Boston Alternative Energy Facility

Statement of Common Ground between Alternative Use Boston Projects Limited and the Environment Agency

Planning Inspectorate Reference Number: EN010095

Date: ~~October-December~~ 2021

View 8: Looking south from Footpath Bost/13/3 near St Nicholas's Church, Skirbeck Conservation Area and properties off The Featherworks / Skirbeck Gardens

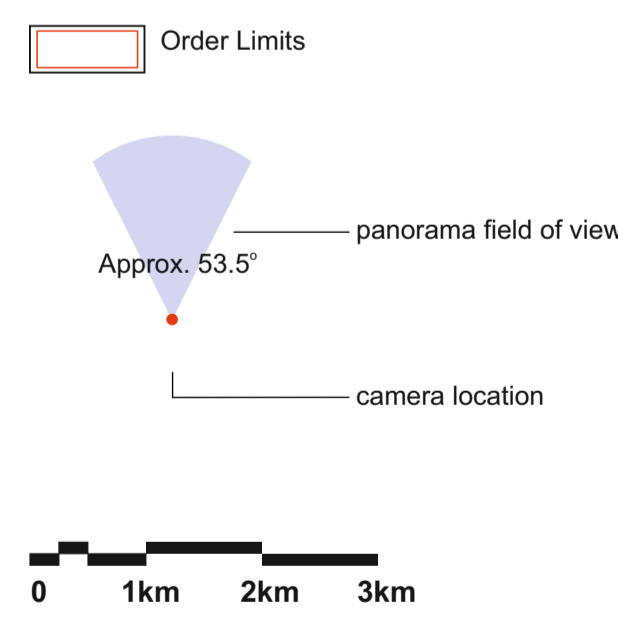
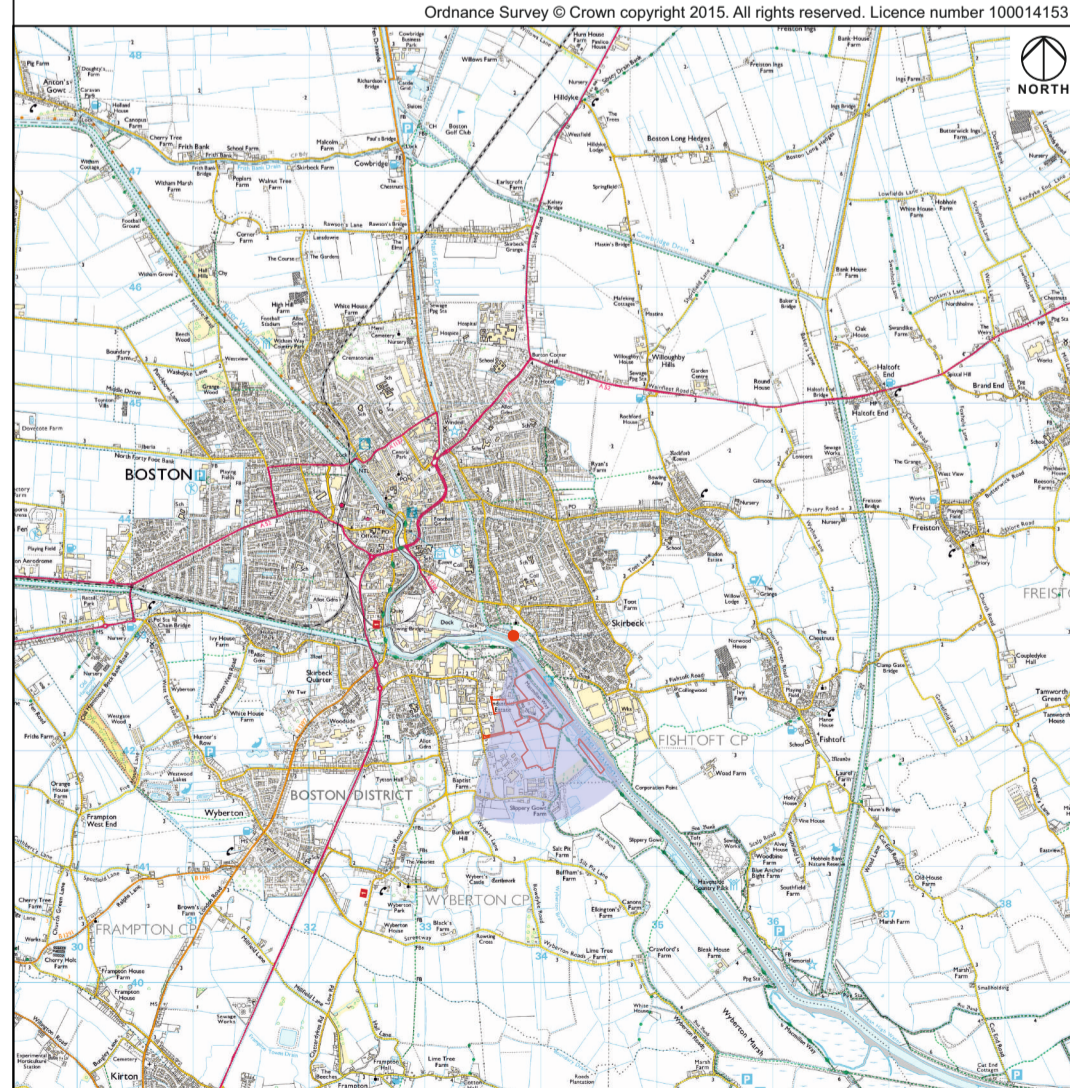
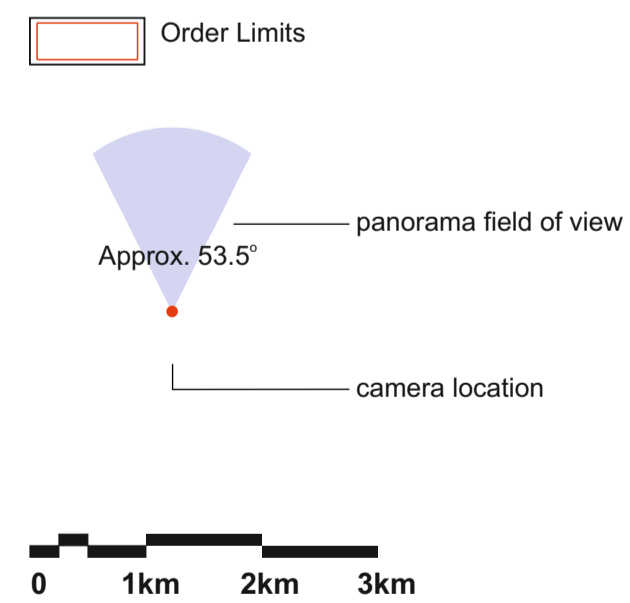
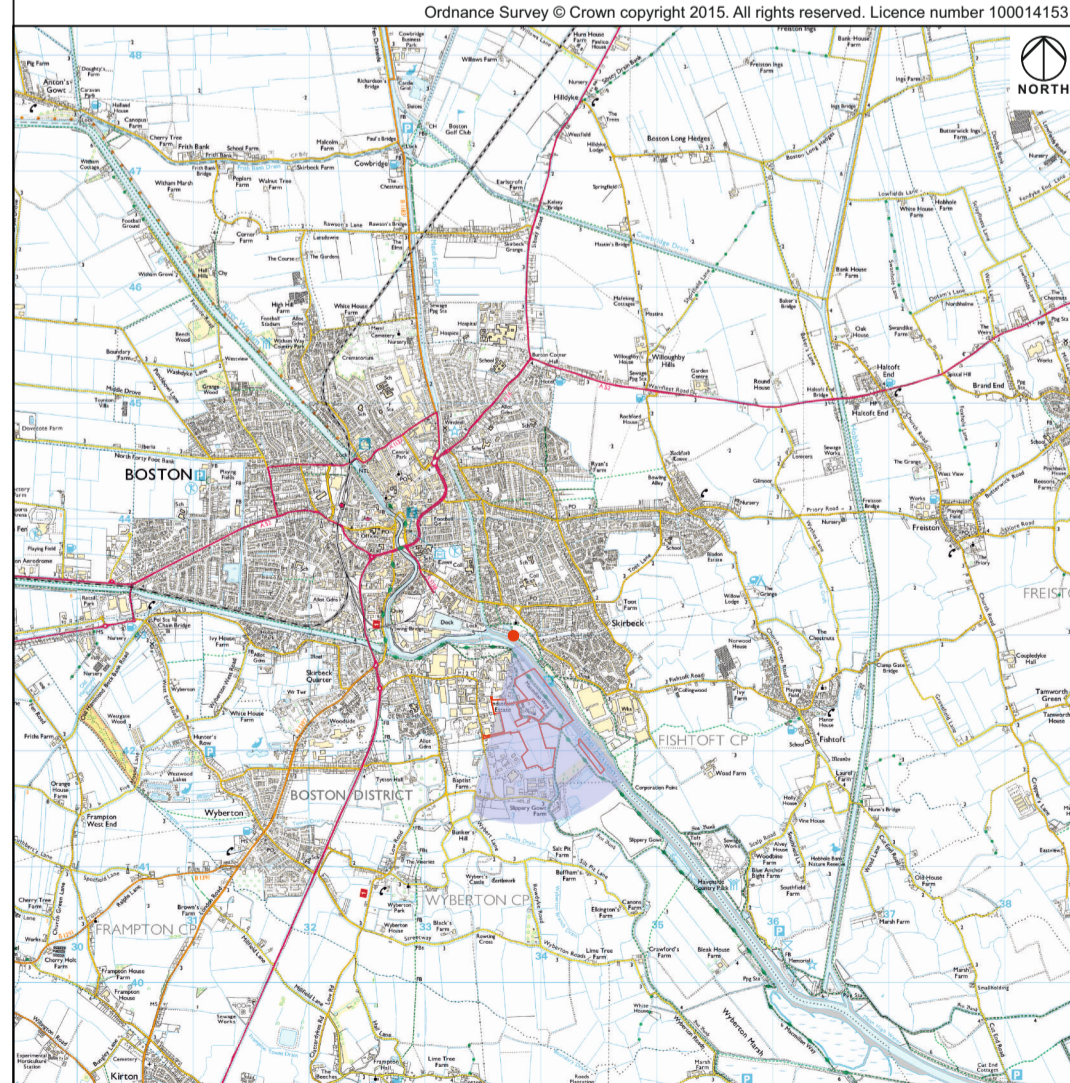
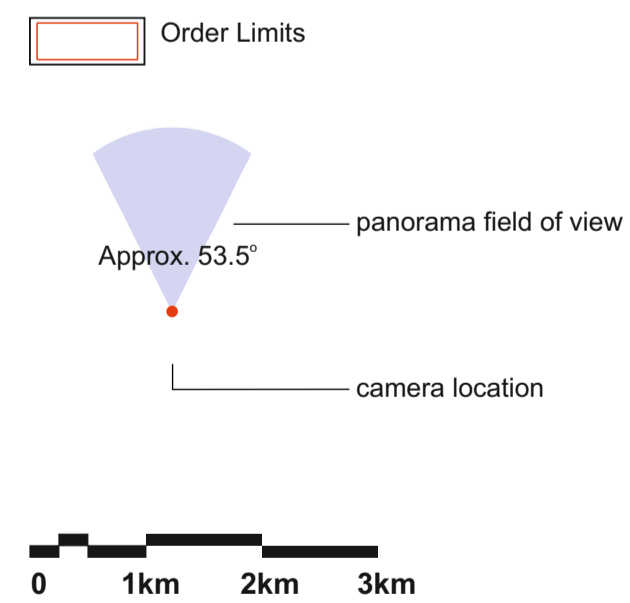
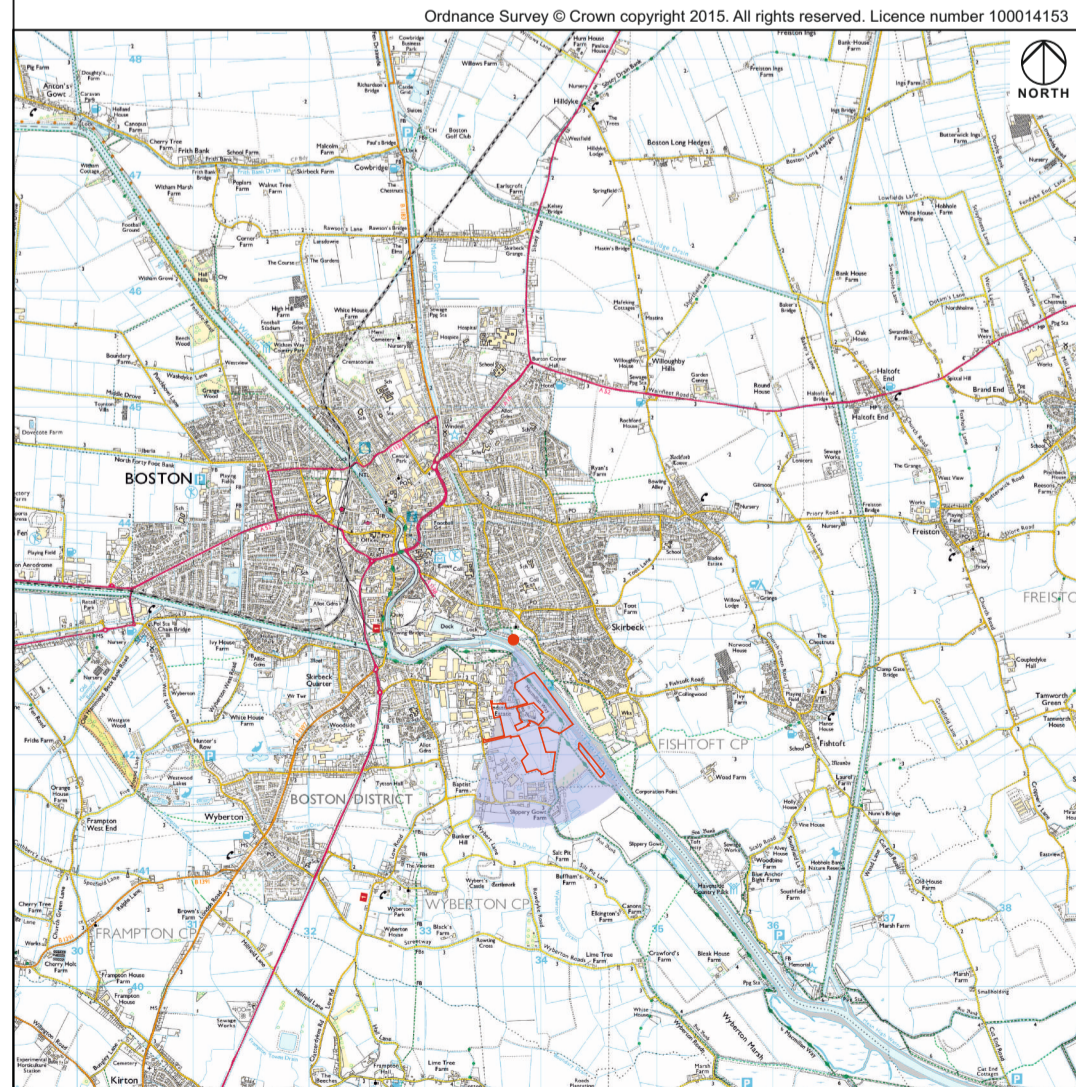
9.0 Landscape and Visual Impact Assessment					
EA 9.1	Chapter 9 Landscape and Visual Impact Assessment (document reference 6.2.9, APP-047)	Landscape and visual impact assessment	<p>The EA notes further information is needed on visible plumes.</p> <p>The EA notes a large visual impact on the landscape.</p> <p><u>The EA acknowledges that the information submitted is consistent with what it would expect to see from this type of process.</u></p>	<p>A technical note is being produced to address visible plumes, this will be provided to the EA. Further information on visible plumes was provided within documents submitted at Deadline 1 and 2 including an updated Chapter 9 Landscape and Visual Impact Assessment (LVIA) (document reference 6.2.9(1), REP1-004) and Chapter 14 Air Quality (document reference 6.2.14,</p>	<p>Under discussion <u>Agreed</u></p>

SoCG Reference	Document Reference	Topic	EA's Comment	AUBP Response	Status
				<p><u>REP1-006) and updated photomontages (document reference 6.3.7(1), REP2-017 and document reference 6.3.9(1), REP2-019).</u></p> <p>The LVIA identifies significant, irreversible adverse visual effects upon certain visual receptors. Effects upon wider landscape character from visible plumes are lessened due to the existing baseline and presence of industrial and infrastructure features.</p>
